## PLANNING CONSULTATION RESPONSE

<b>Application No</b>	2025/1071
<b>Proposal</b>	Erection of 9no detached dwellings
<b>Address</b>	Alexandra Working Mens Club, 59 High Street, Royston, Barnsley, S71 4RF
<b>Date of Consultation Reply</b>	11/03/2026
<b>Consultee</b>	Katie Lawrence, Planning Ecologist

Appendix II. POST DEVELOPMENT PLAN.

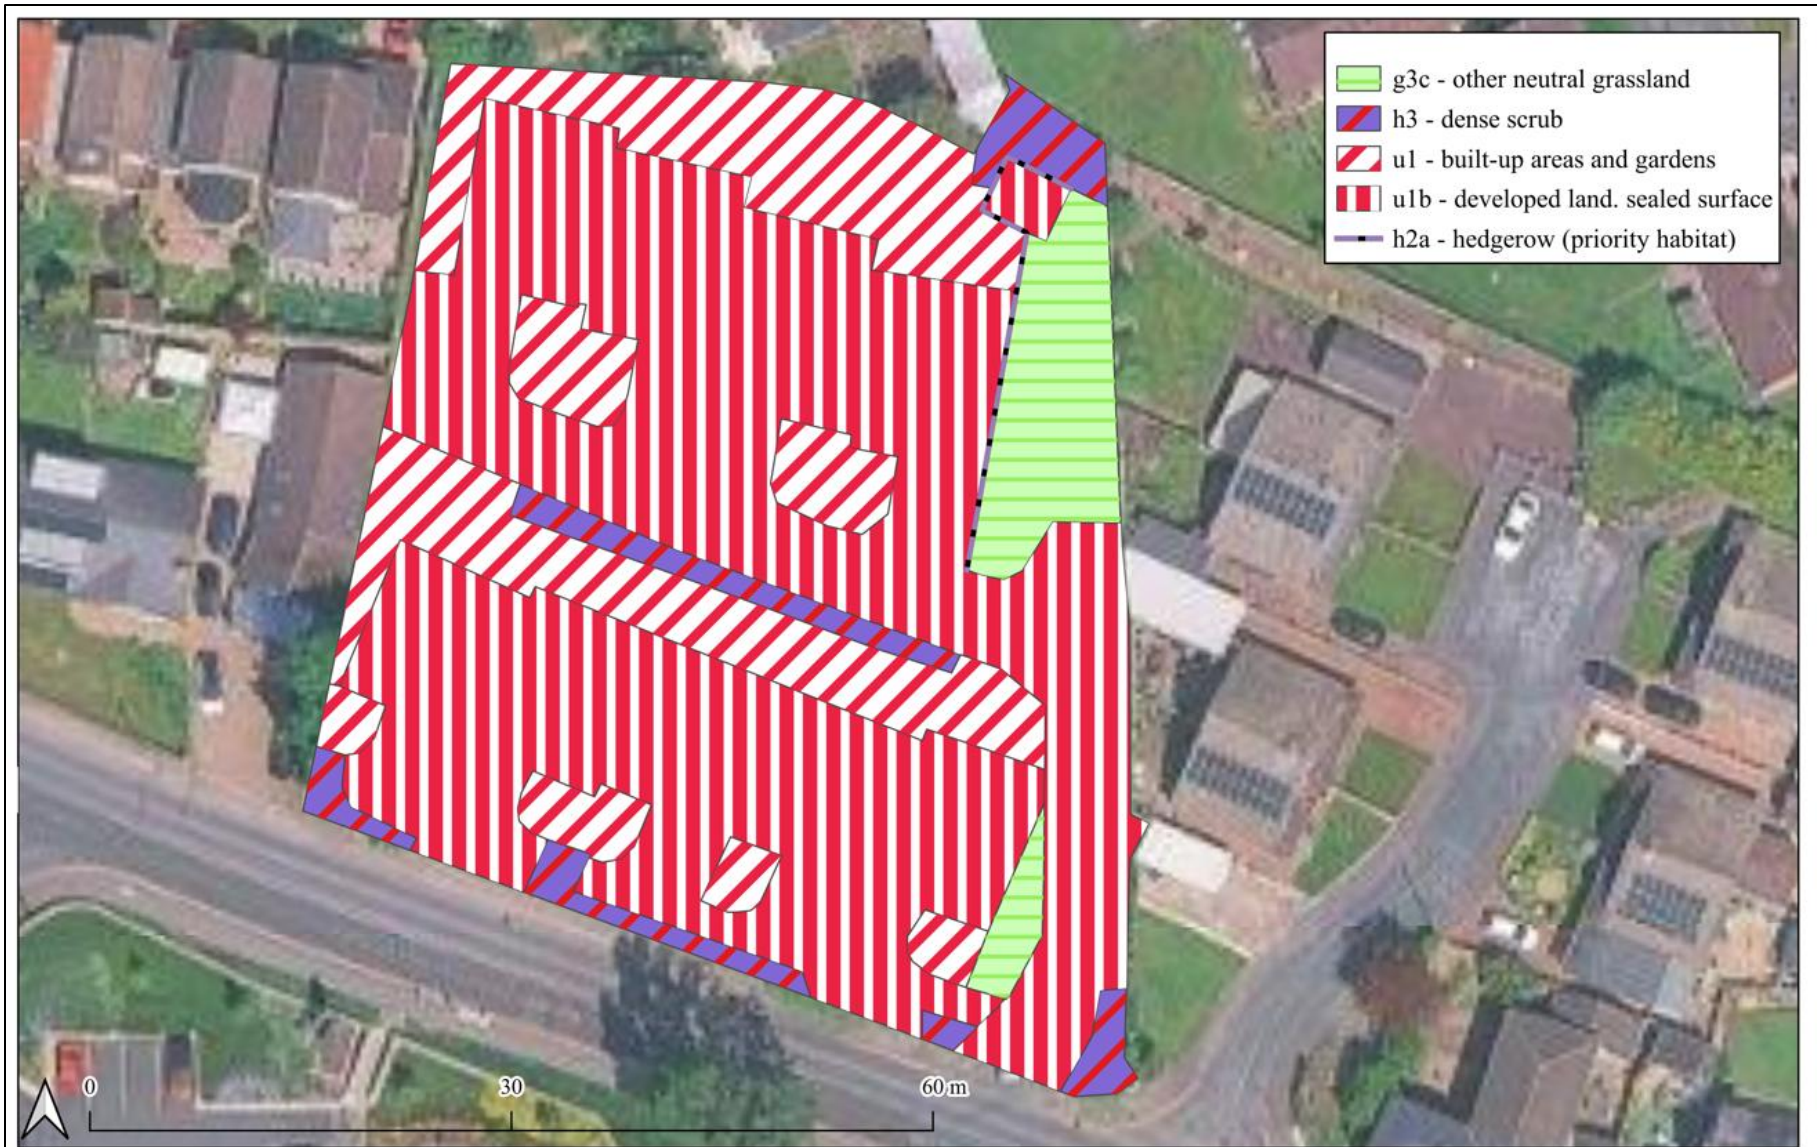
- The BNG report details post development proposals including the planting of native shrubs, hedgerows, tree planting and areas of other neutral grassland. It is considered that native tree, shrub and hedgerow planting would be appropriate for the site; however, the creation of other neutral grassland may be difficult to achieve particularly as this is proposed in association with tree planting and likely to be overshadowed. Modified grassland is considered to be more appropriate in these areas. The metric should be amended accordingly. In addition, the post-development habitat plan included within the appendix of the BNG report should be amended to include proposed tree planting.
